Subject: FW: app3/2014/0689 Cowley Brook Farm , Longridge

From: Bloomer, David [<mailto:David.Bloomer@lancashire.gov.uk>]
Sent: 20 August 2014 14:30
To: Claire Booth
Cc: ENV LHS Customer Service
Subject: app3/2014/0689 Cowley Brook Farm , Longridge

I would have to express some reservations regarding this application . The proposal is for 2 x 2bed holiday cottages and whilst the parking standards for a 2 bed dwelling would suggest only 1 parking place being required , the 2 bedrooms may be occupied by an extended family arriving in 2 cars which would result in on street parking close to a crossroad junction which would not be acceptable. In addition the parking for the property fronting Higher Road is remote from the entrance which would increase the likelihood of parking taking place on the highway / verge.

PROPOSED SITE PLAN

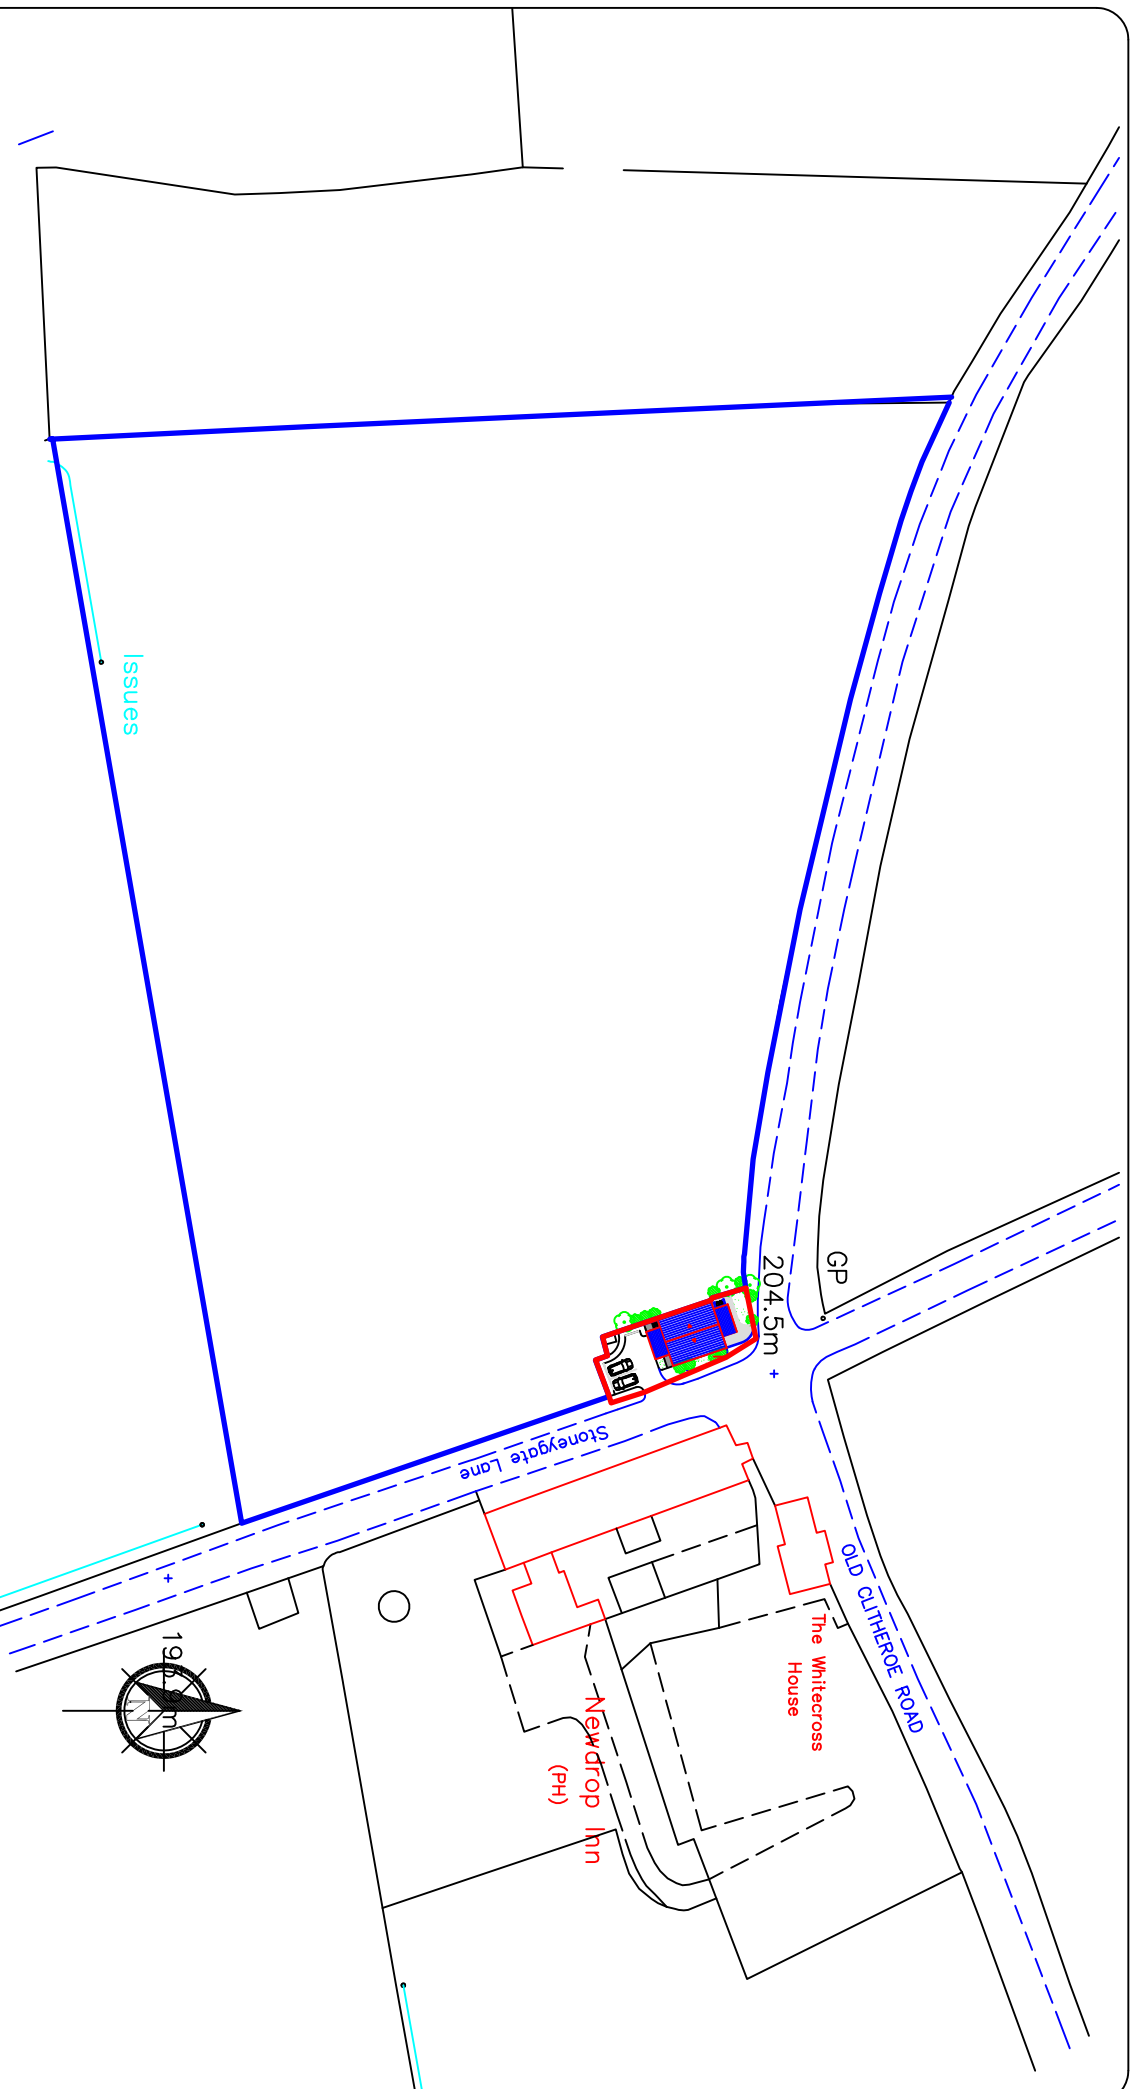
Finally the proposal would utilise an existing field gate, if there is an alternative gate where is it? if not then I would need to know where it is to be located so I can assess the highway safety implications.

In respect of the application as submitted I would have to raise highway safety concerns and therefore recommend that the application be refused
